**Re: SSD 15\_7256: Environmental Impact Statement ResourceCo Resource Recovery Facility Wetherill Park**

**Proposed ResourceCo Resource Recovery Facility  
35 Frank Street, Wetherill Park (SSD 15\_7256)**

**SSD 15\_7256 - SUBMISSION - PROPOSED WASTE AND RESOURCE  
MANAGEMENT FACILITY AT 35-37 FRANK STREET, WETHERILL PARK**

SITE PLAN-PART 1
1 : 250@A1
1 : 500@A3

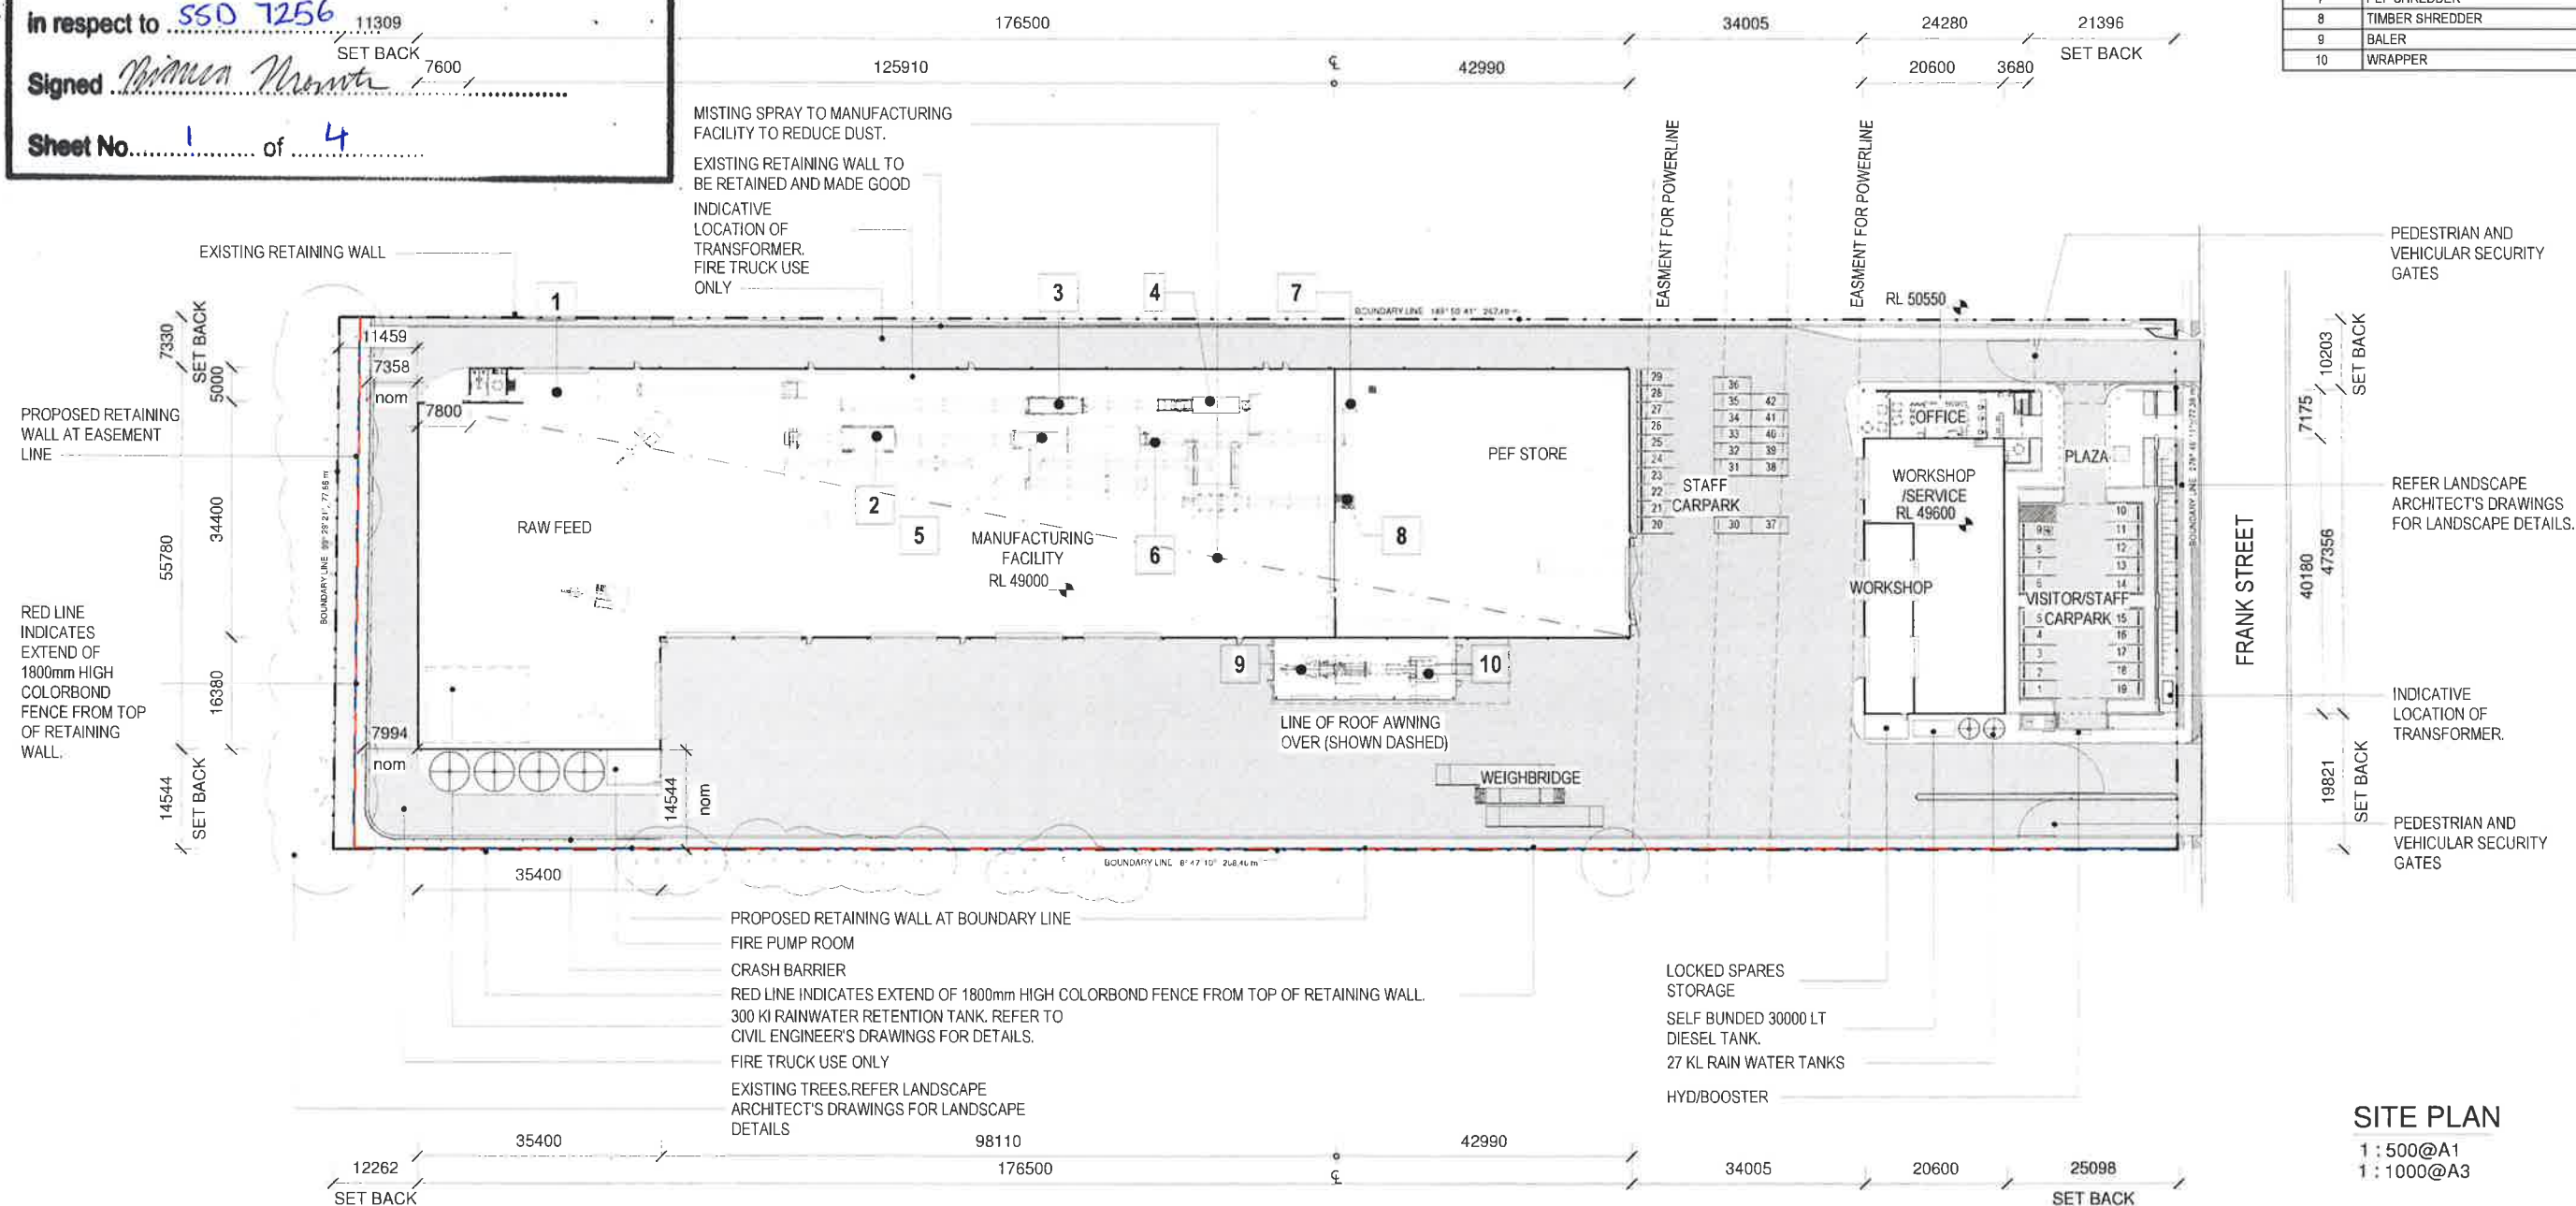
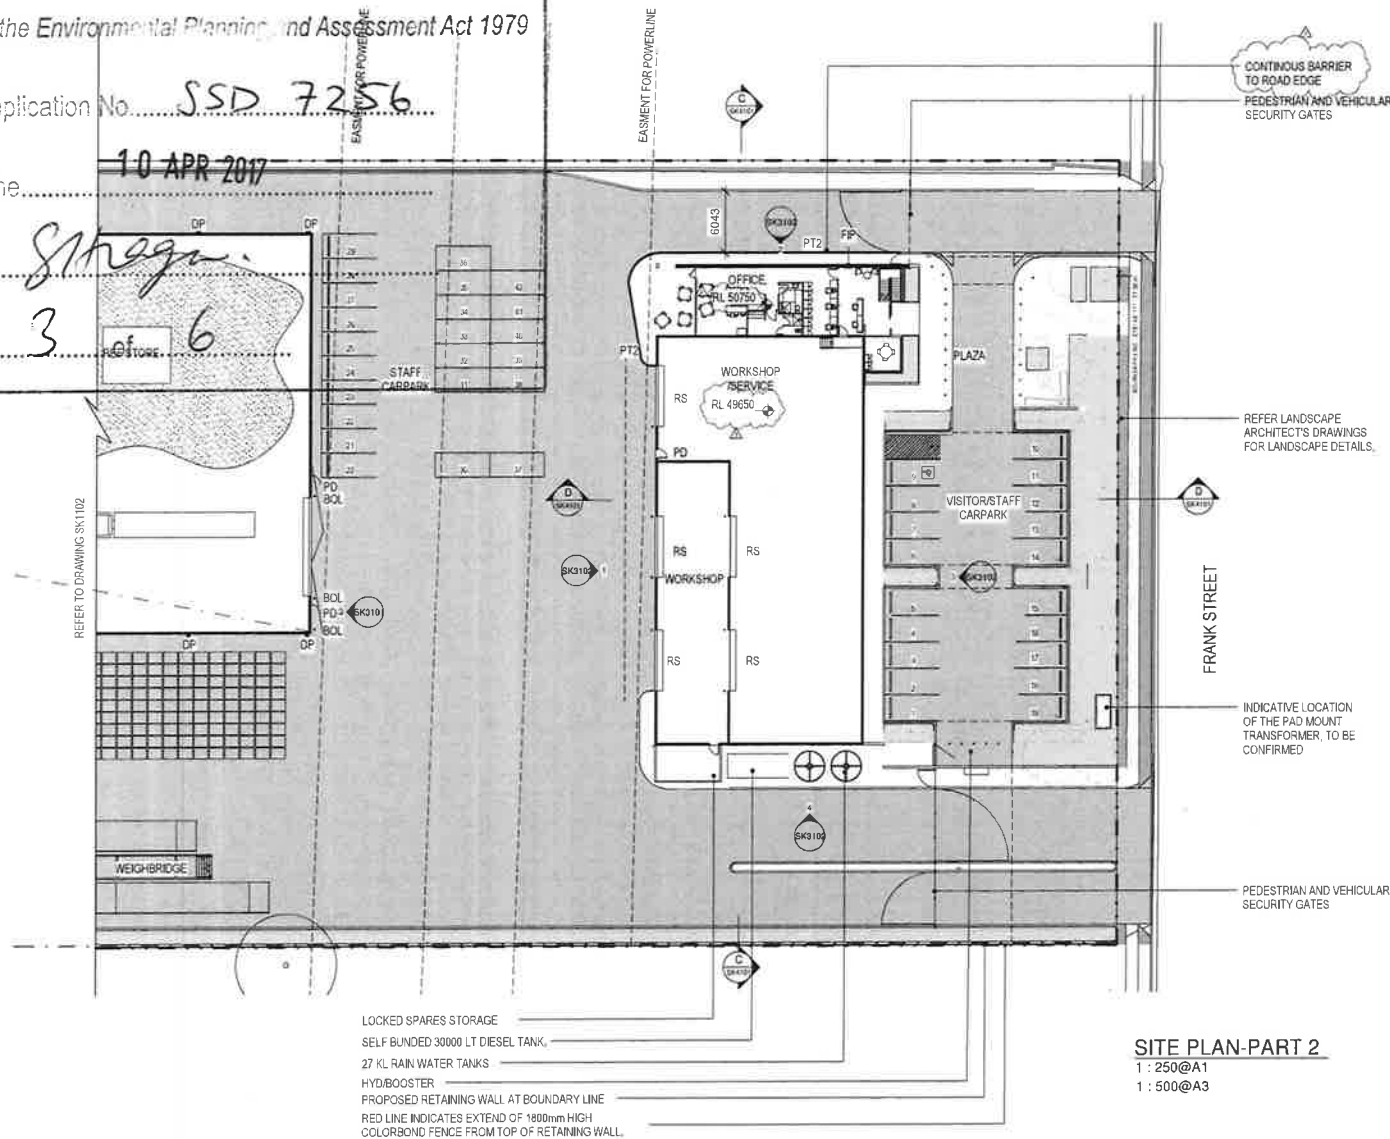
- a) That the proposal shall be referred to the Roads and Maritime Services for comment.
- b) That the existing vehicular crossings in Frank Street shall be retained. All trucks shall enter and exit using the western vehicular crossing, to be widened to 13.5 metres and separated by a raised concrete median 1 metre wide in order to accommodate B-Double and articulated vehicles.

- c) That the existing crossing on the eastern side of the site shall be used by staff and visitor vehicles and shall be a combined driveway.
- d) That demand for car parking shall be determined by a car parking survey of a comparable facility in order to provide on-site parking.

- e) That manoeuvring on site, particularly in the vicinity of car parking space No.2 shall be re-evaluated to ensure compliance.
- f) That the applicant shall liaise with Council's Subdivision Branch in regard to replacing the drainage pit grate located within the western vehicular crossing.
